OBJECTION to planning reference A/64/18/T – Caffyns – Removal of Trees with TPO

I note planning application A/64/18/T which states that the two Copper Beach trees subject to the TPO have 'had their life expectancy compromised as a result of approved building works'.

Drawing title
Site Plan

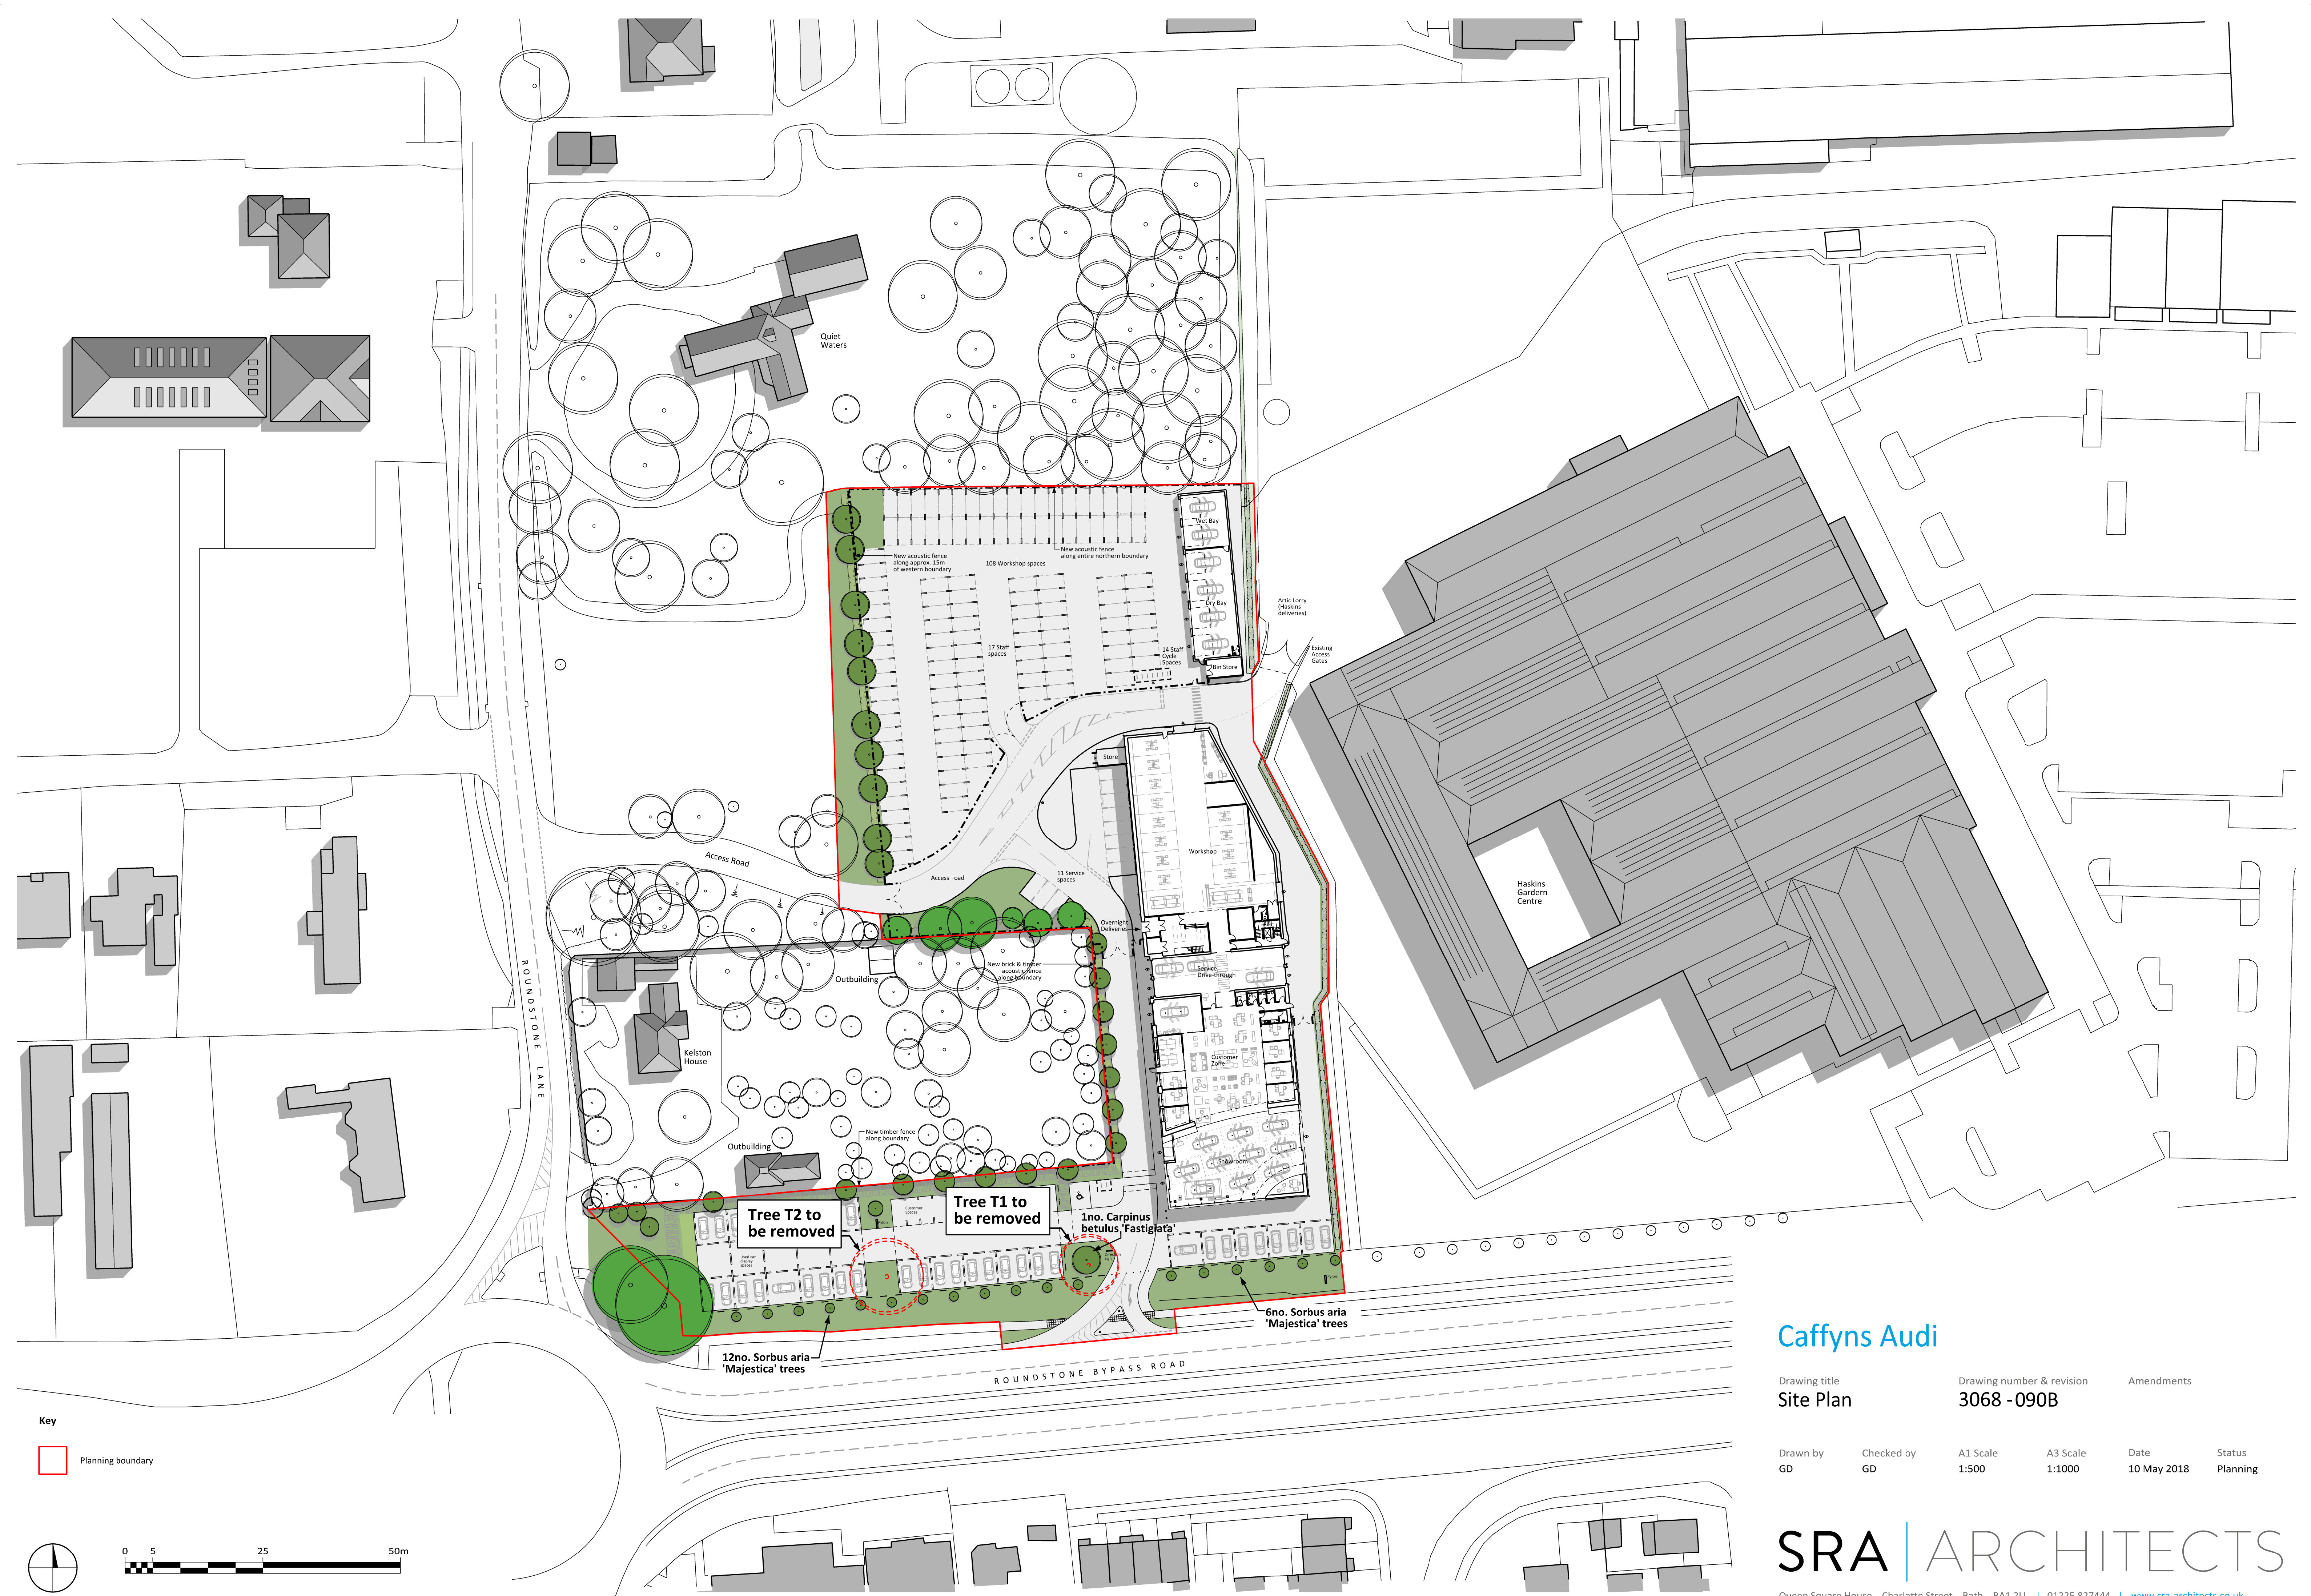
This illustrates the placement of protective fencing and some ground works around the western-most tree. It can be seen that the fencing on the East side of the tree is barely 1 metre from the tree, contravening the directives contained in the original TPO. It should also be noted that this is deliberate and not accidental as the ground works illustrated have been excavated to create the forecourt.

These illustrate the Copper Beech nearest to the new building and particularly the entrance driveway to the new dealership. It can be seen that the placement and the direction of the driveway is intended to pass very close to the tree. This infers that either the installation of the driveway has been located in error or that it was always intended to compromise the tree and facilitate a process of removal.
